Your ref: SSD 17352813
File no: MC-21-00001

**SSD 17352814 – Huntingwood Processing Facility Expansion – 65
Huntingwood Drive, Huntingwood**

Blacktown Council's submission to SSD 17352813 – Huntingwood Processing Facility Expansion

LEGEND

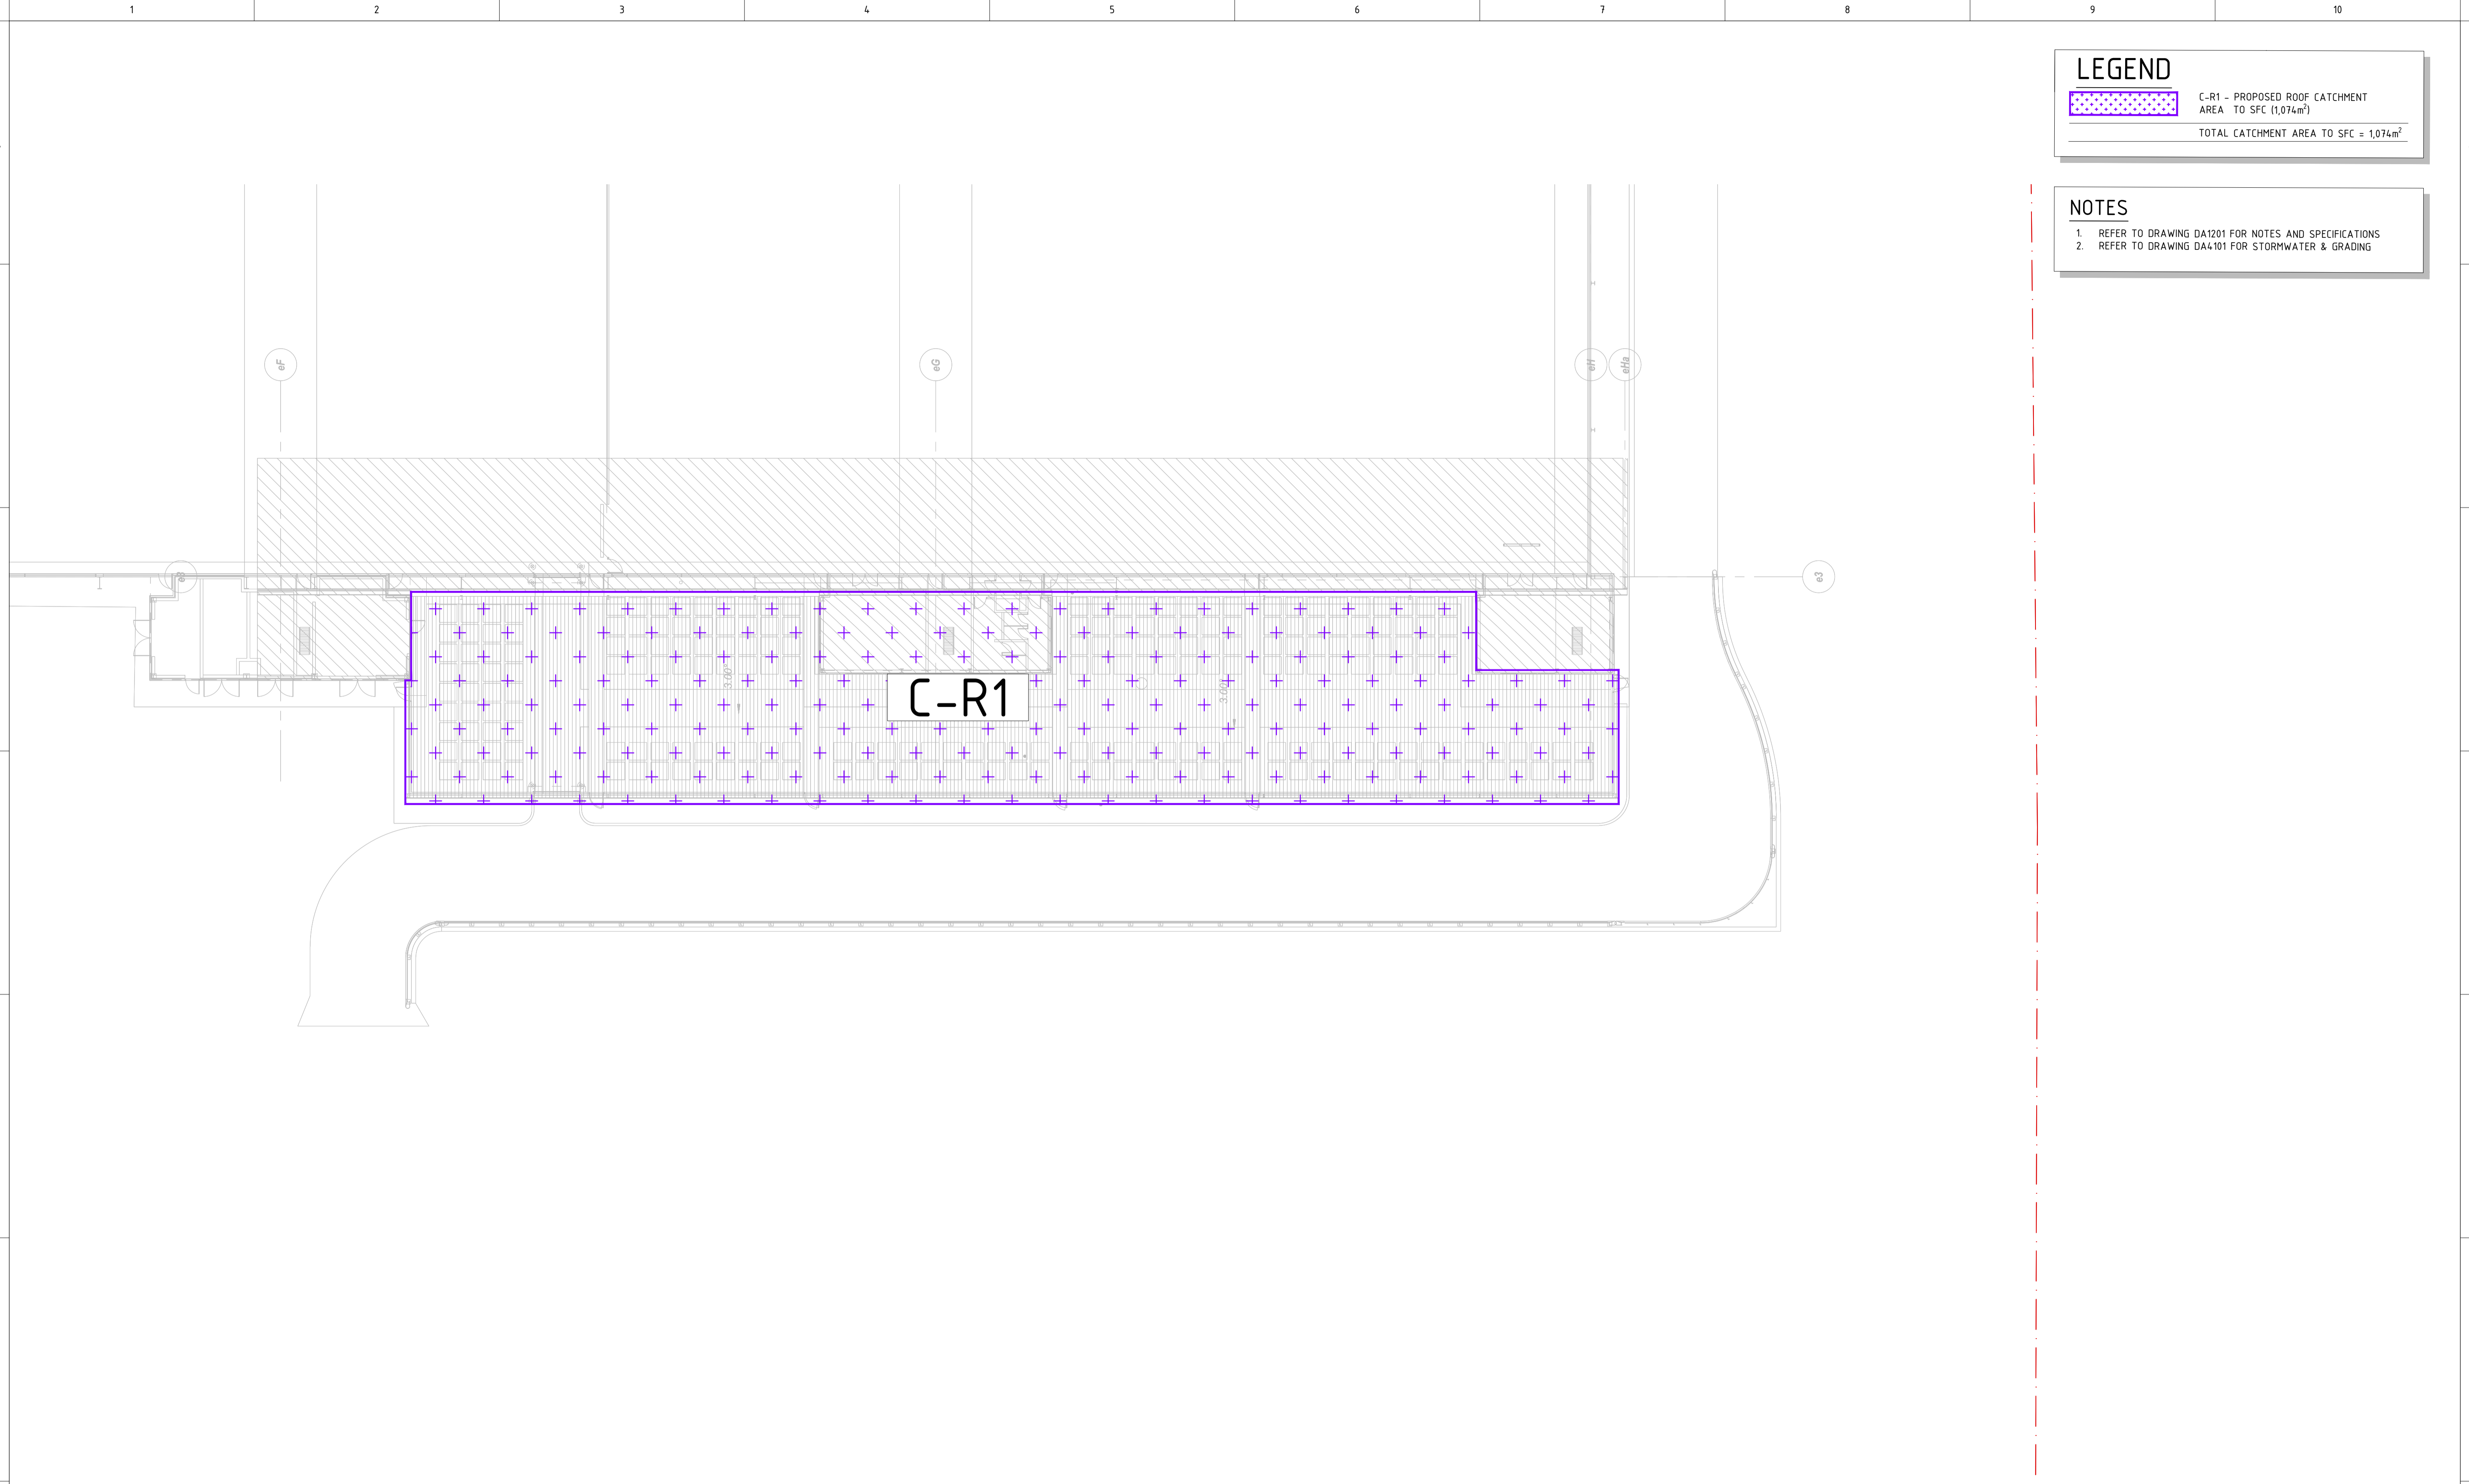
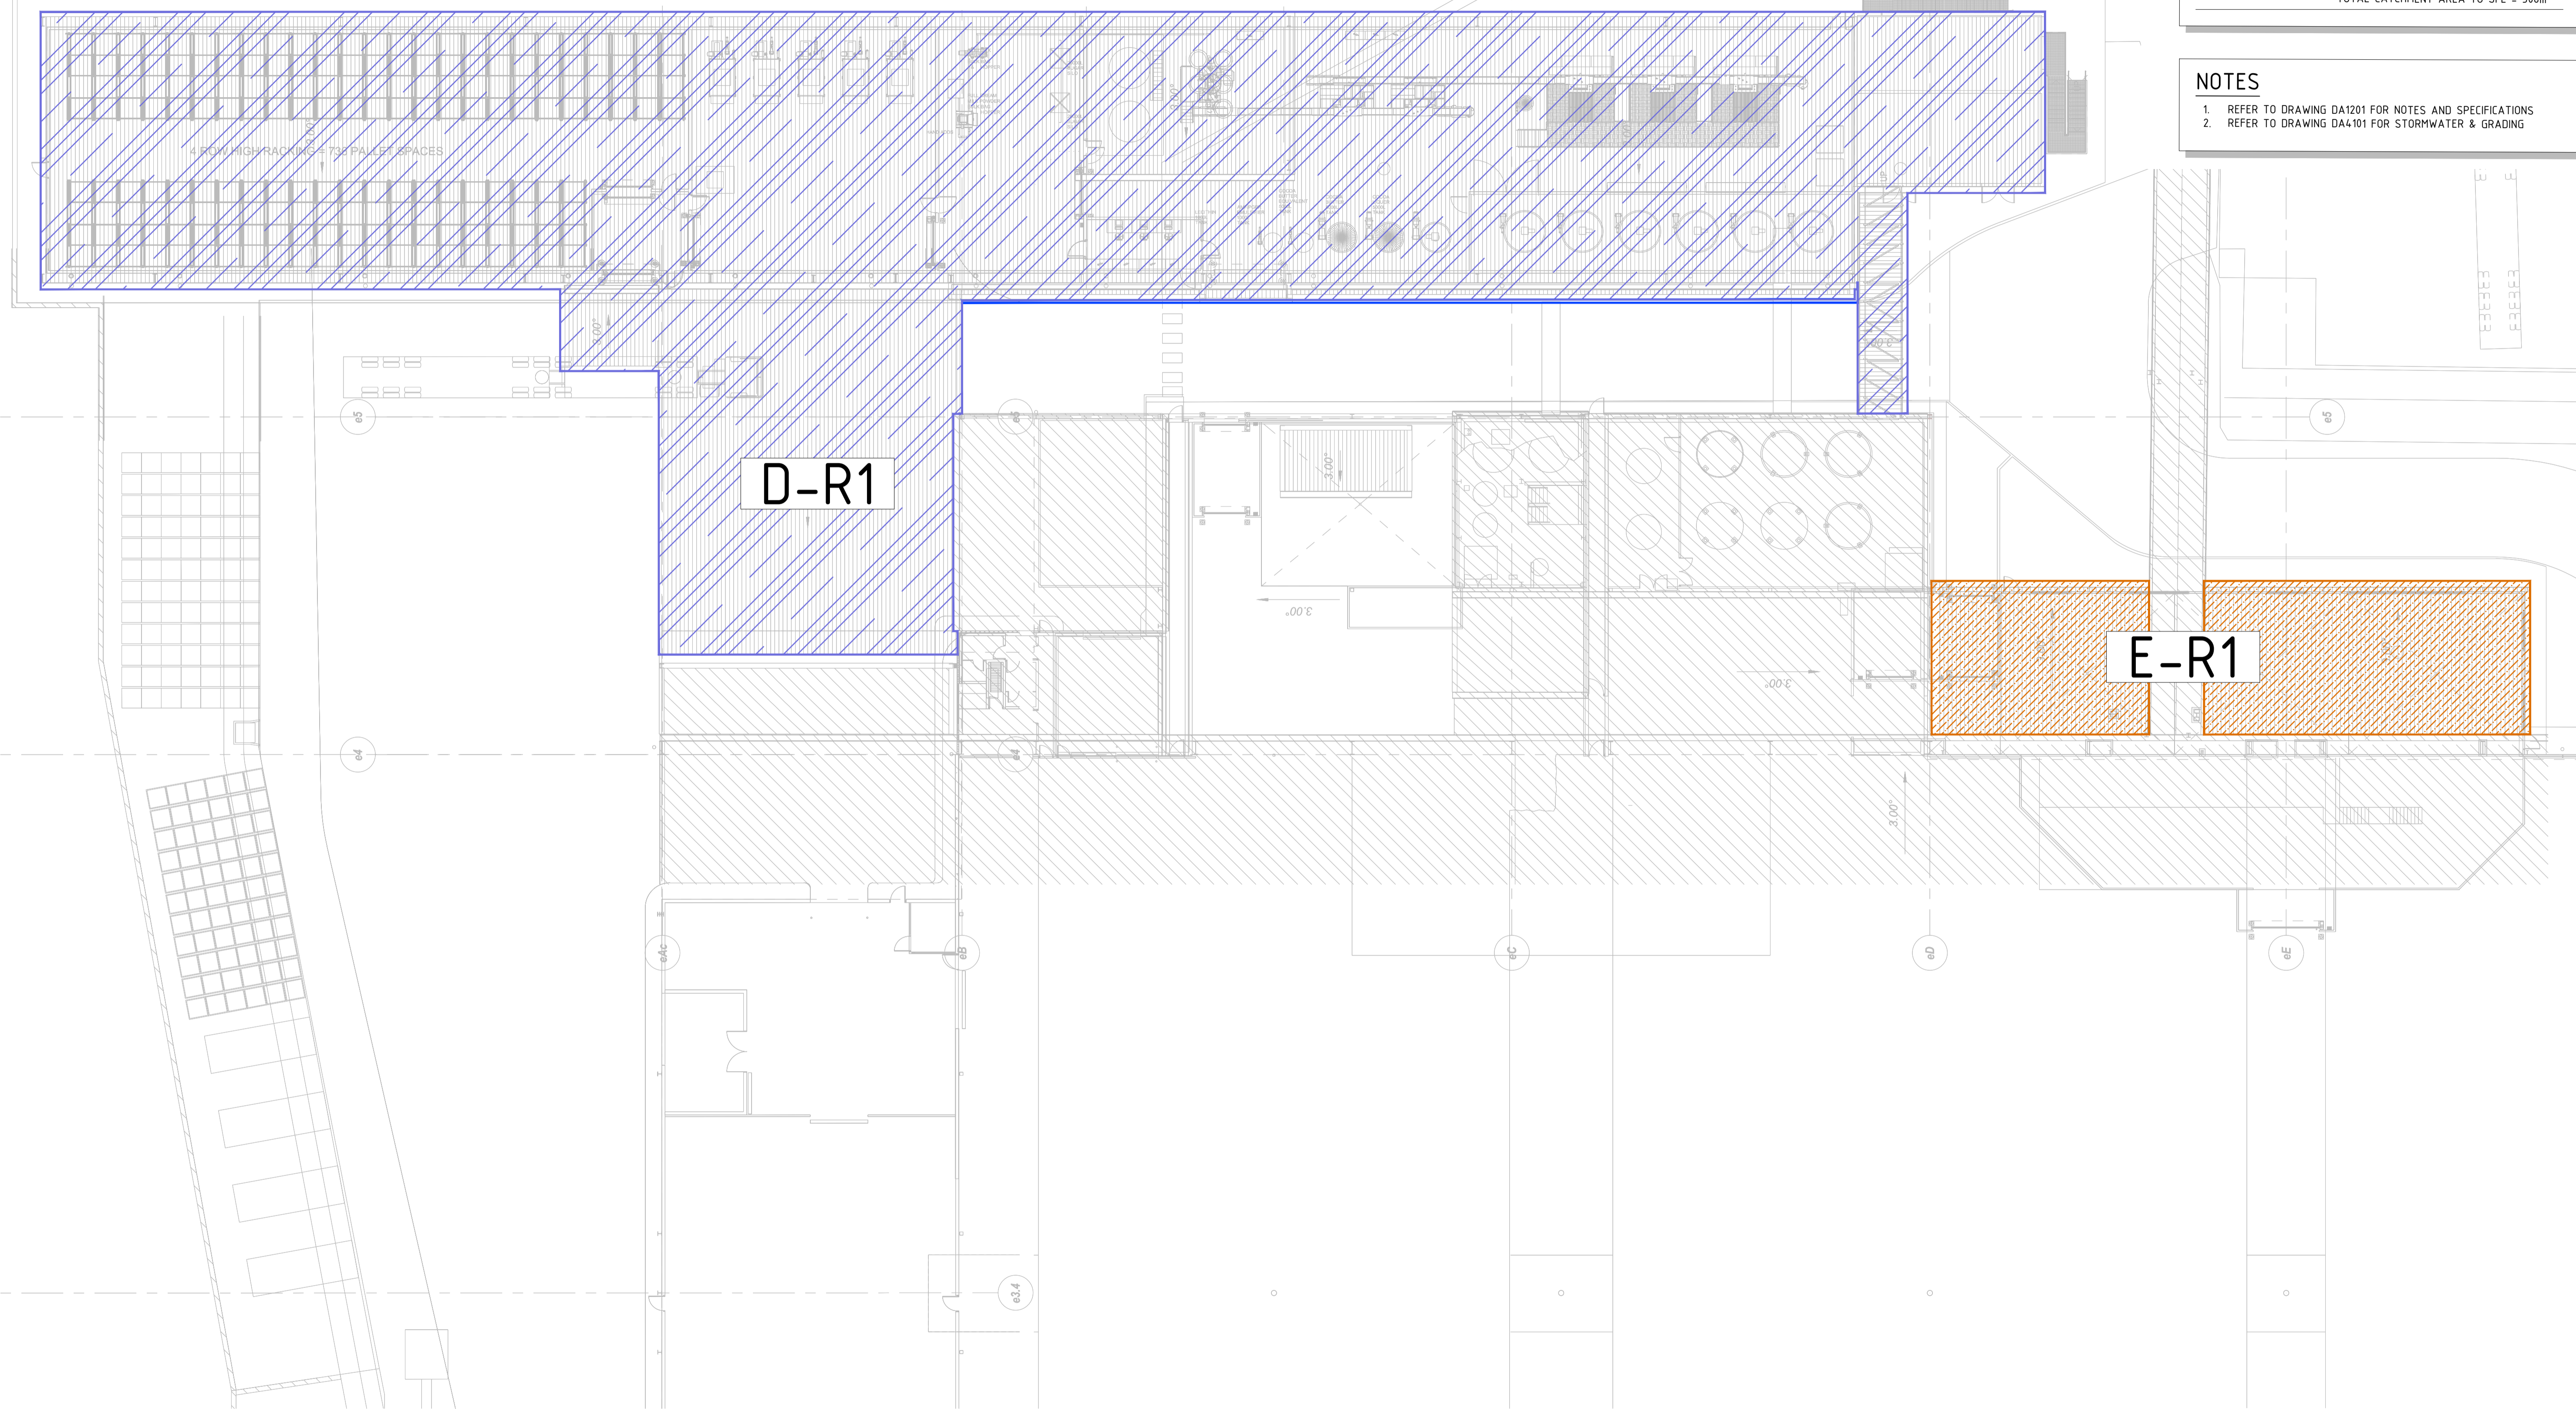
- a. Tertiary treatments in series are not permitted.
 - Provide separate and total catchments for each Jellyfish.
 - Provide the complete jellyfish calculations as per the WSUD developer handbook chapter 12.13 and in particular 12.13.3.
 - The jellyfish levels are not as per 12.13.3. inlets and outlets are to be set at different levels.
 - Provide the 1EY HGL for the jellyfish calculations.
- b. Revise stormfilter designs and catchment plans as a result.
- c. Provide invert levels of drainage network and ensure that backwater levels from proprietary systems are considered.
- d. Submit amended plans and updated MUSIC (standard) model.
